24/00045/FUL
25.01.2024

**RSA HOUSE, WESTERN ROAD, BRACKNELL, BERKSHIRE, RG42 1RX
SECTION 73 OF THE TOWN AND COUNTRY PLANNING ACT 1990: APPLICATION FOR A MINOR-
MATERIAL AMENDMENT IN RELATION TO PLANNING PERMISSION REF: 22/00879/FUL**

DRAWING NO. 19103 - SK30 REV B

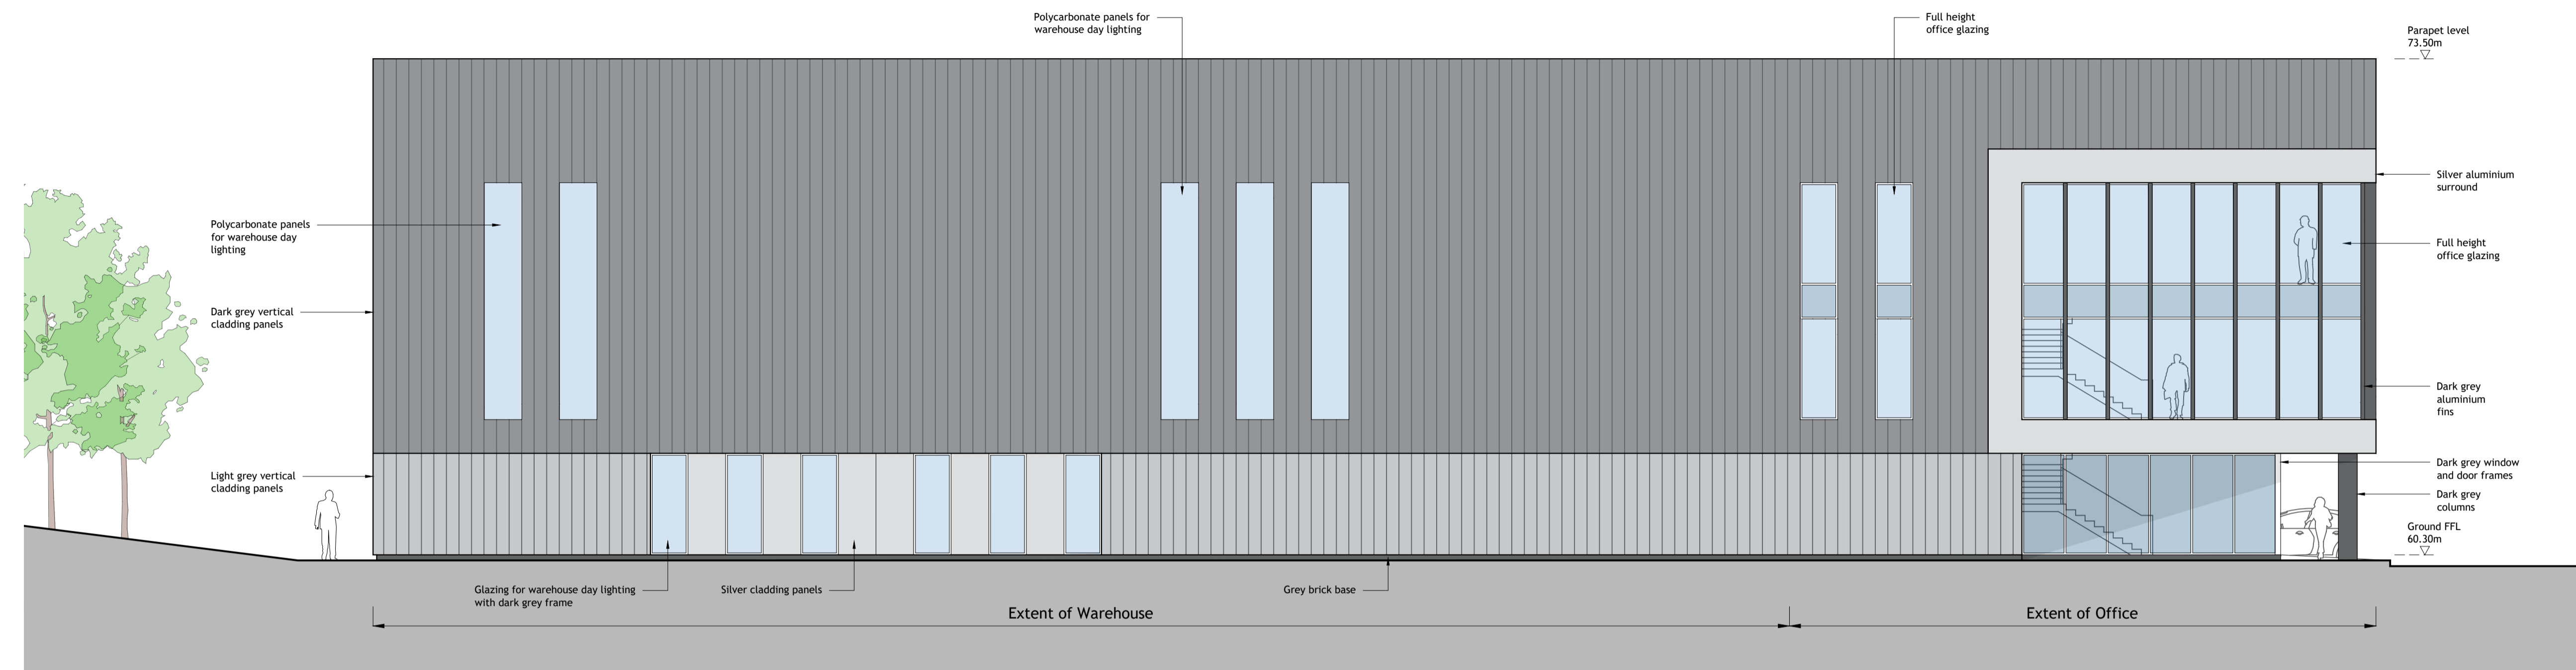
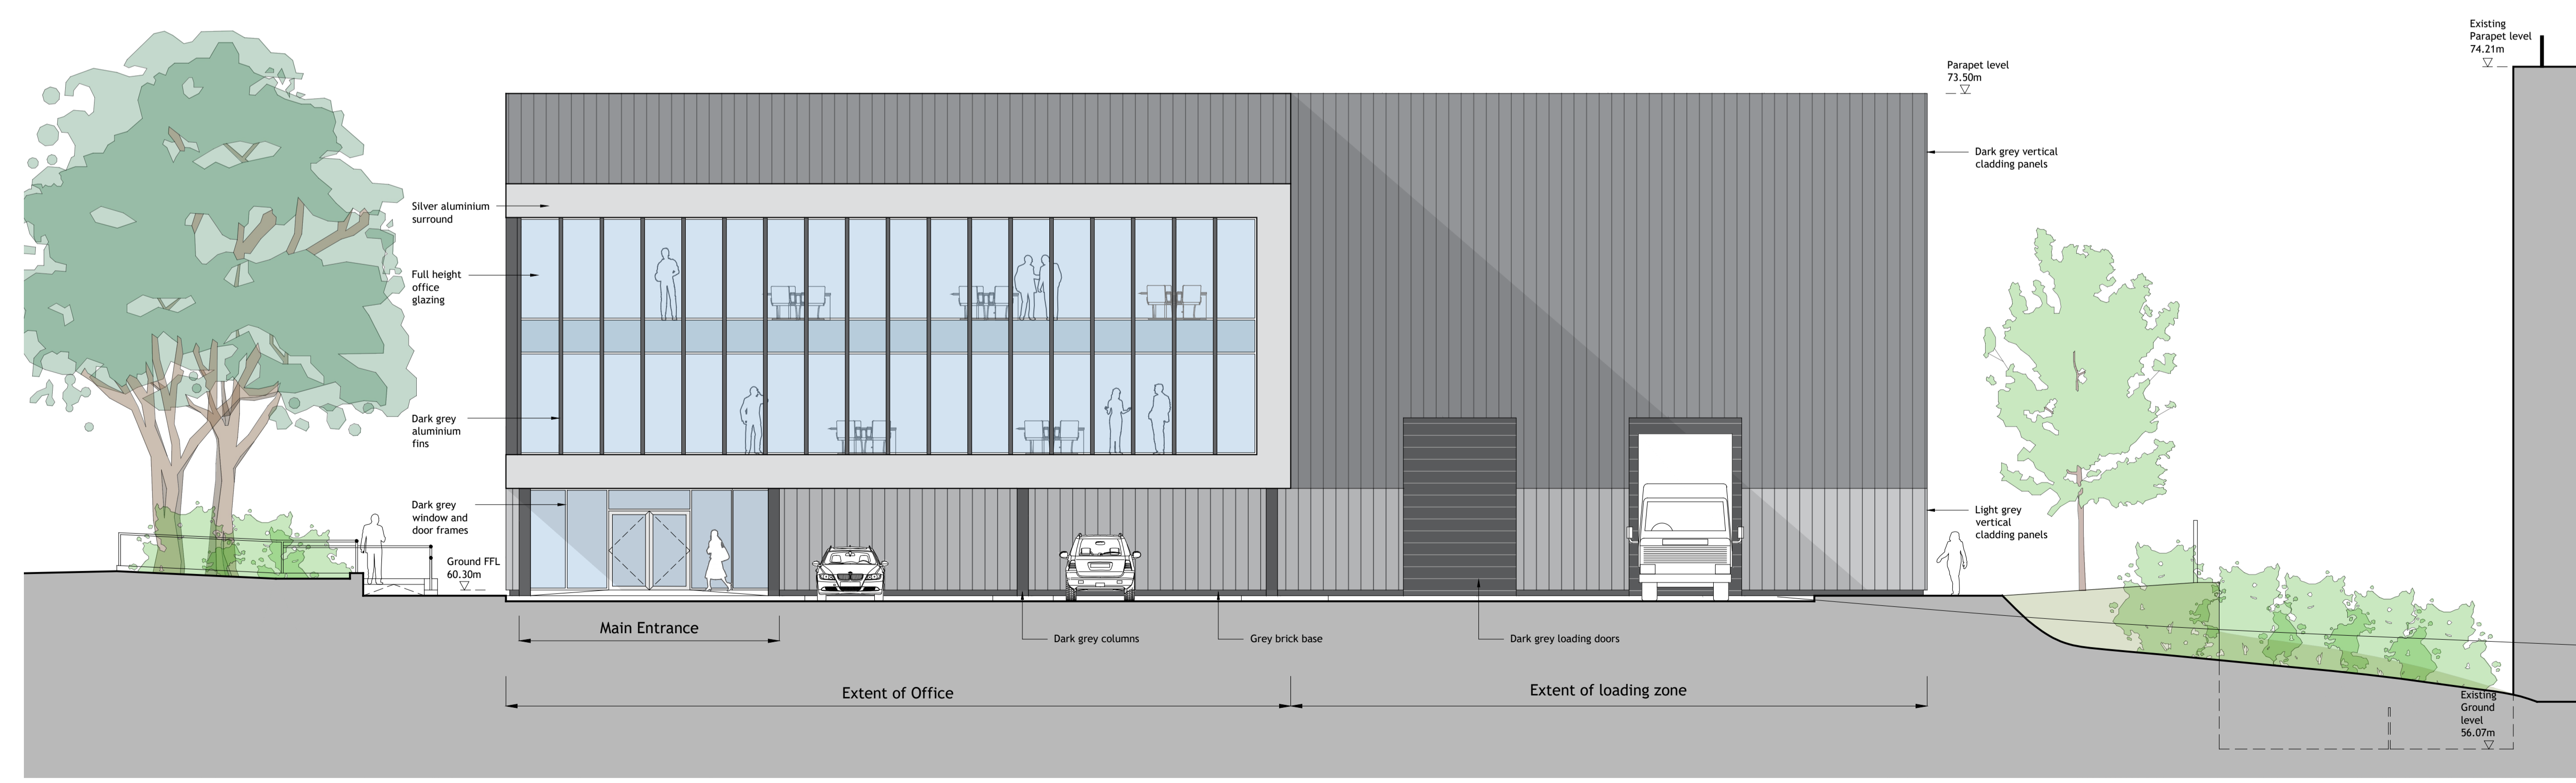
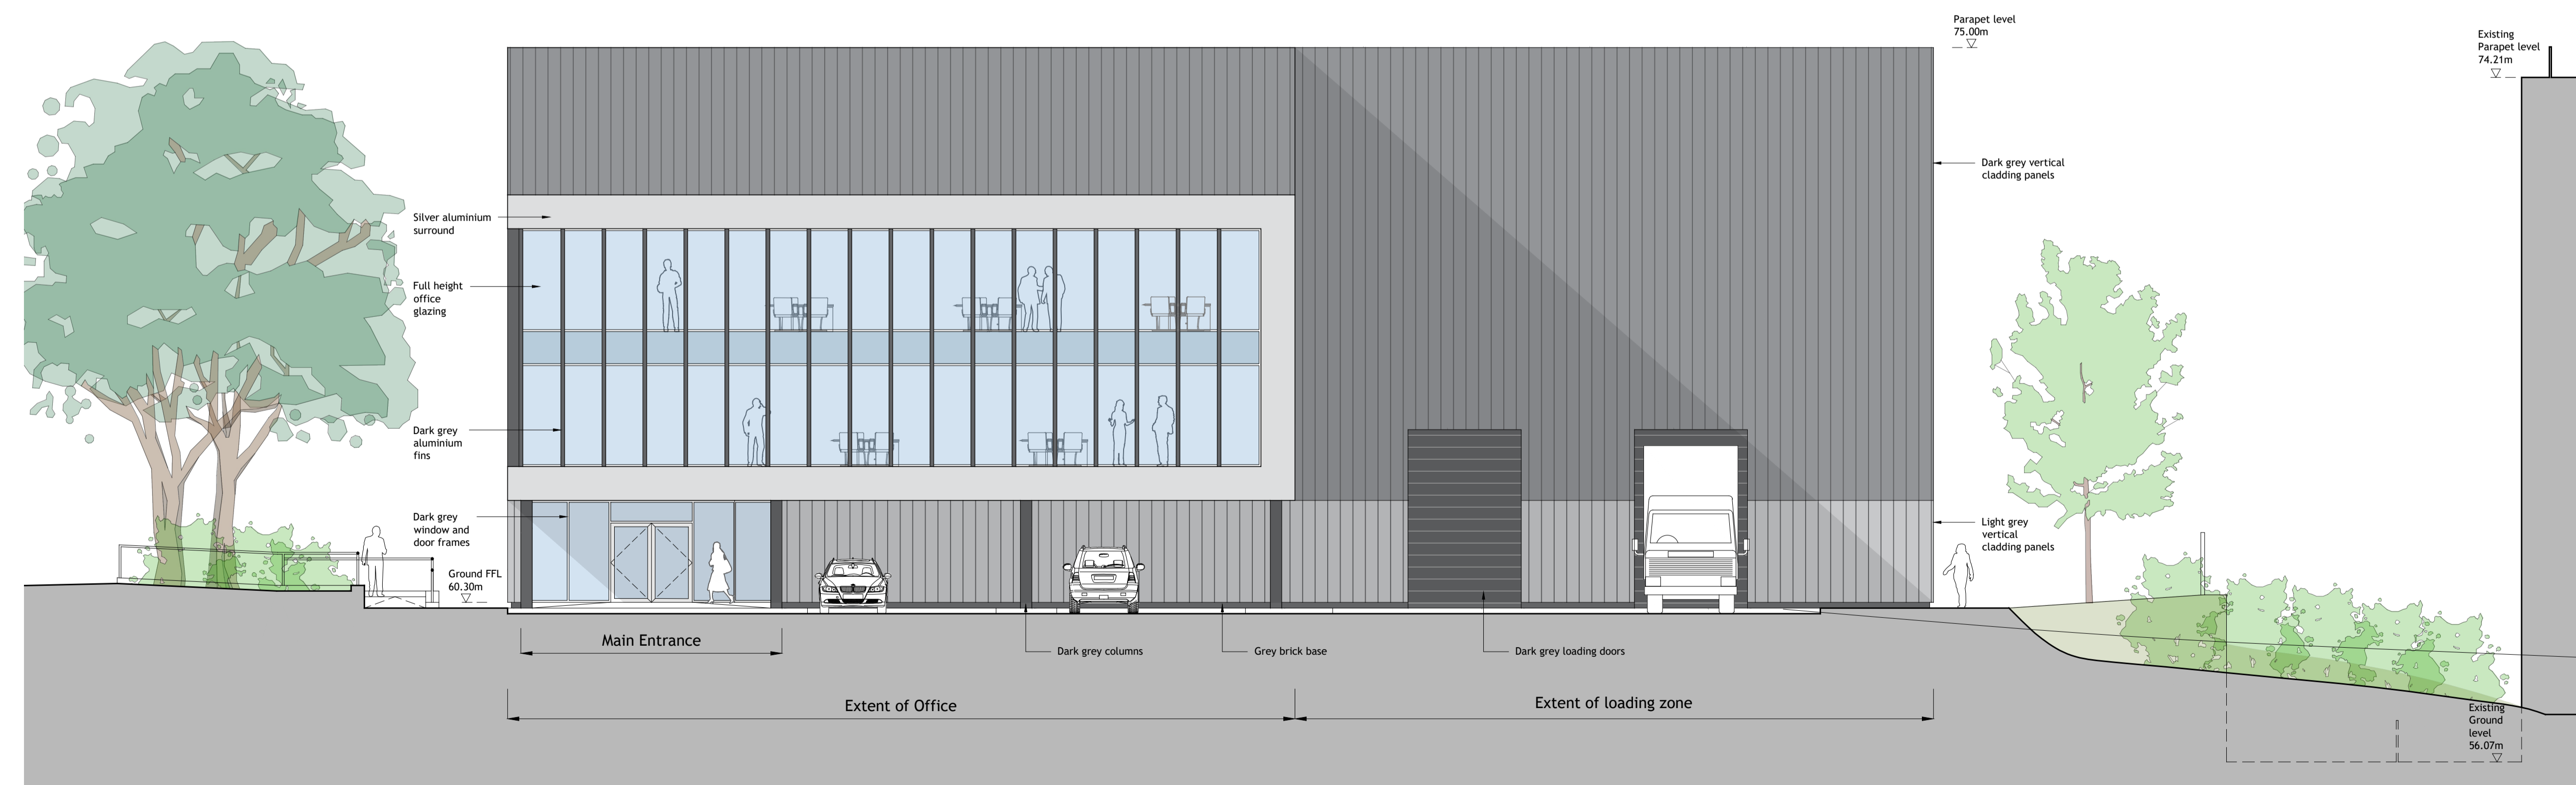
The Applicant has been marketing the Site to potential occupiers for a considerable amount of time with limited success. Tentative demand has emerged recently and the Applicant has engaged in comprehensive discussions with a potential occupier. However, as part of the discussions the potential occupier has stated they would require an increase in height of the building by 1.50m to progress discussions further, therefore taking the overall eaves height of the building from 13.2m to 14.7m.

Drawing Title	Approved Drawing Reference (drawings to now be superseded)	Proposed Drawing Reference (to supersede Approved Drawings)
Proposed Site Sections	19103-SK29 Rev A	19103-SK34
Proposed Elevations	19103-SK30 Rev B	19103-SK35
Proposed Elevations	19103-SK32	19103-SK36

In the context of the above, it is considered the proposed 1.50m increase in height of the approved scheme represents a ‘minor material amendment’, and therefore, under Section 73 of the Town and Country Planning Act 1990, an application to vary the conditions under the approved decision notice represents the most appropriate planning route.
